DEVELOPMENT REVIEW BOARD
TRANSPORTATION DEVELOPMENT

DRB Project Number: 2019-003092
Ridgecrest and San Mateo

SUBJECT: Vacation

DATE: January 8, 2020

**TIERRA WEST, LLC**  
5571 MIDWAY PARK PL NE  
ALBUQUERQUE, NEW MEXICO 87109  
(505) 858-3100

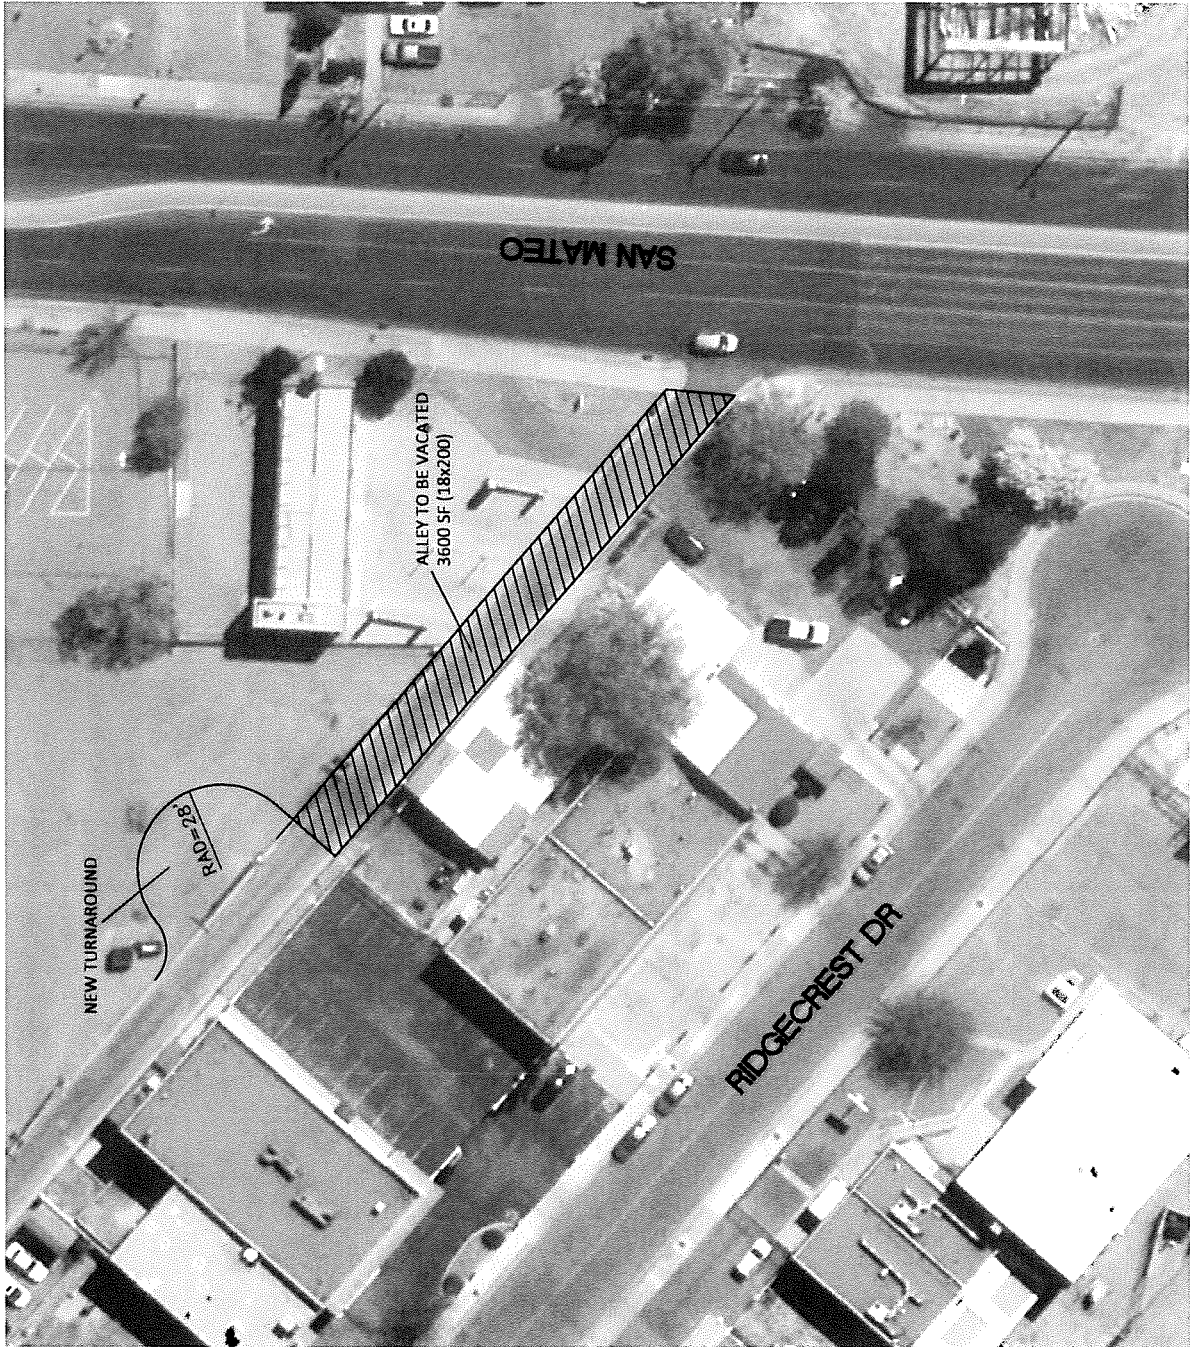
1. Transportation has no objection to the vacation.
2. Coordinate with the Fire Marshall on proposed layout shown in exhibit. The new turnaround radius combined with width of alleyway do not meet fire code standards for a road that would be over 150 feet long. Place these improvements on an infrastructure list.
